SUBMISSION FROM ROSE BAY RESIDENTS ACTION GROUP (RBRAG)**FORMAL OBJECTION TO SSD – 86017721, 23-31 DOVER ROAD, ROSE BAY****30 NOVEMBER 2025****INDEX**

SSD-86017721 23-31 Dover Road, Rose Bay proposes an 8-storey tower with two levels of deep basement excavation (approx. 7–8 m) in the **Rose Bay Settlement Area—a location formally mapped in Woollahra Municipal Council’s (“Council”) Development Control Plans (“DCP”) (Chapter E2) as high-risk** for groundwater, geotechnical instability and flooding. The Proponent’s own reports confirm very loose marine sands, a shallow and tidally influenced aquifer, high-permeability soils, and H5–H6 flood hazard immediately across the site frontage.

DRAWING TITLE:
BASEMENT 02 FLOOR PLAN

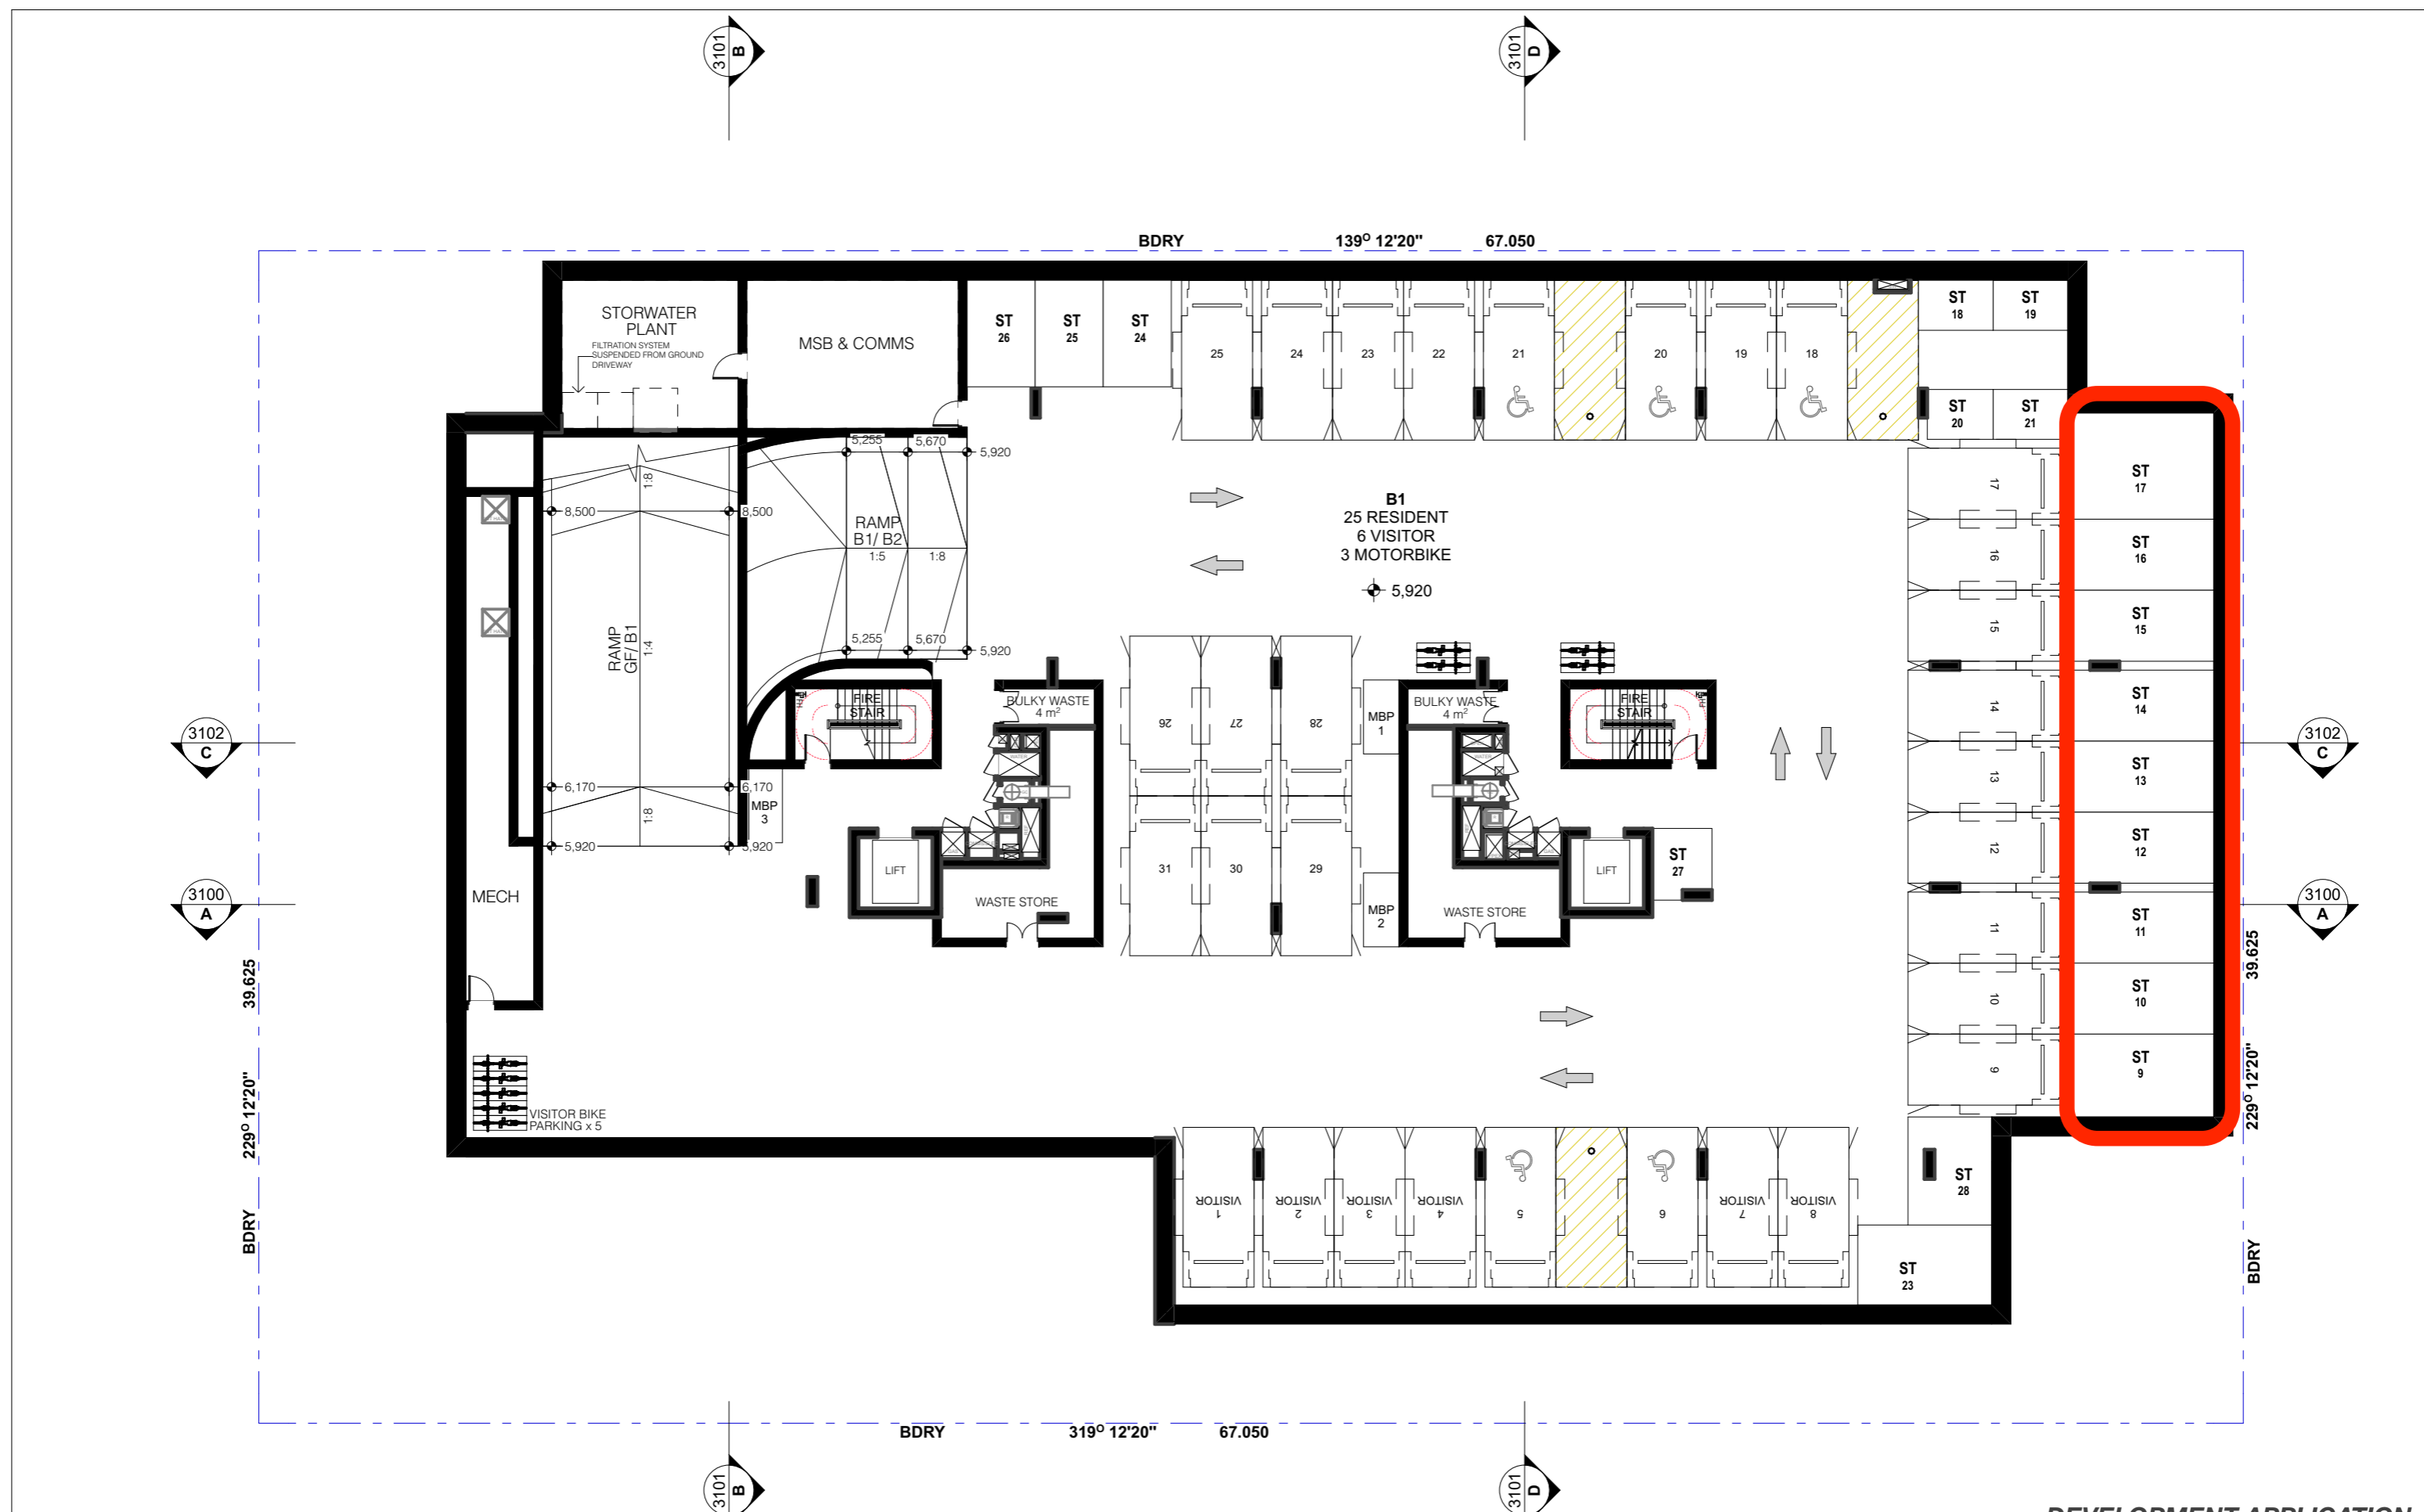
This is not a request to stop development — it is a request to stop avoidable harm. Nothing in the Housing SEPP requires dangerous over-excavation, and nothing prevents the Proponent from redesigning the basement responsibly to exclude excessive areas (for example, those marked as “storage”) which no doubt will be altered to car spaces well in excess of the allowable limits.
